24<sup>th</sup> October 2022

Ref: GH0191/AE

**SUBJECT: TYNEWYDD, LLANFECHAIN –BEAM UNDER KITCHEN FLOOR**

CELLAR FLOOR PLAN  
Drawing No. 16

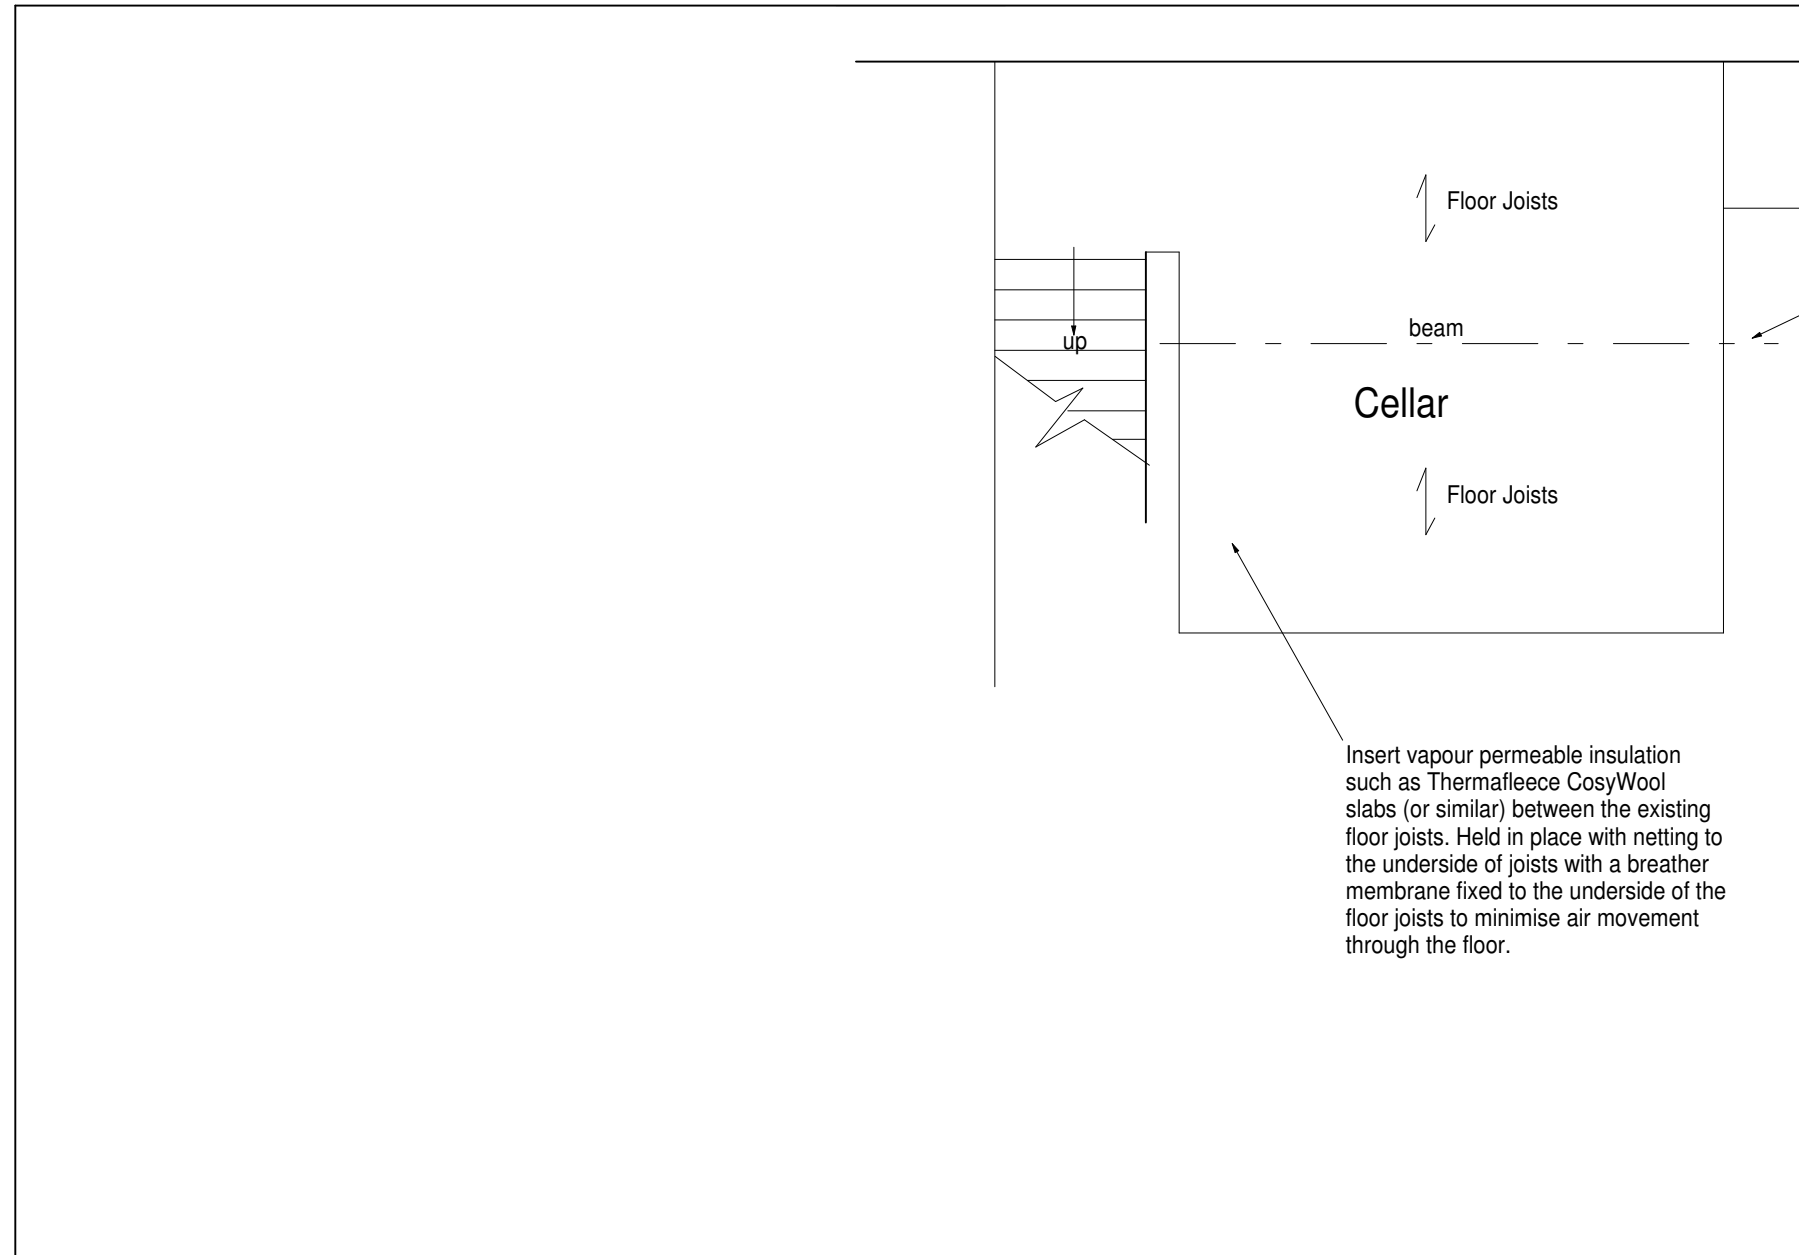
There is evident decay to the ends of the beam. The end supported on the external wall has a temporary acrow support prop in place. It can be seen that the timber bearing within the external wall is decayed and is structurally compromised. There is also evident decay to the existing timber padstone under the beam end. Green staining on the surrounding wall indicates ambient damp conditions.

The other beam end bears on the brick partition wall between the cellar and the stairs up to ground floor. The beam end and timber bearer are also decayed at this end, compromising the structural functionality of the beam. Again, extensive staining indicates ambient damp conditions.

A new supplementary structure would comprise new steel beams either side of the existing beam to support the floor while retaining the existing beam in place with no loss of original fabric. This would make the existing beam structurally redundant and would therefore require no significant intervention to repair or strengthen the ends. The only intervention would be bolts through the timber to the beams either side so that the new beams could carry the weight of the original beam. Due to the decay of the existing timber bearers, new padstones would be required. A new timber bearing plate would likely decay in the wall in the same manner as previous plates (it can be seen under the beam end that successive plates have decayed). The higher stress concentrations under the ends of steel beams also makes concrete padstones more suitable and stable. As this option would provide minimal loss of existing original fabric and is a simple solution, it is recommended as the preferred solution to be adopted. C-section beams have been proposed to minimise the width of new bearing area, keeping the new padstone sizes down to a minimum. Although there are issues surrounding the use of concrete in traditional masonry walls and the lack of permeability of the concrete, the padstone does not surround any other masonry units (as opposed to pointing, where the water cannot permeate out of the joints surrounding the stone if done in a cement-based mortar), and as a proportion of the

area of the wall, the padstones are sufficiently small so as not to affect the wider permeability of the wall as a whole.
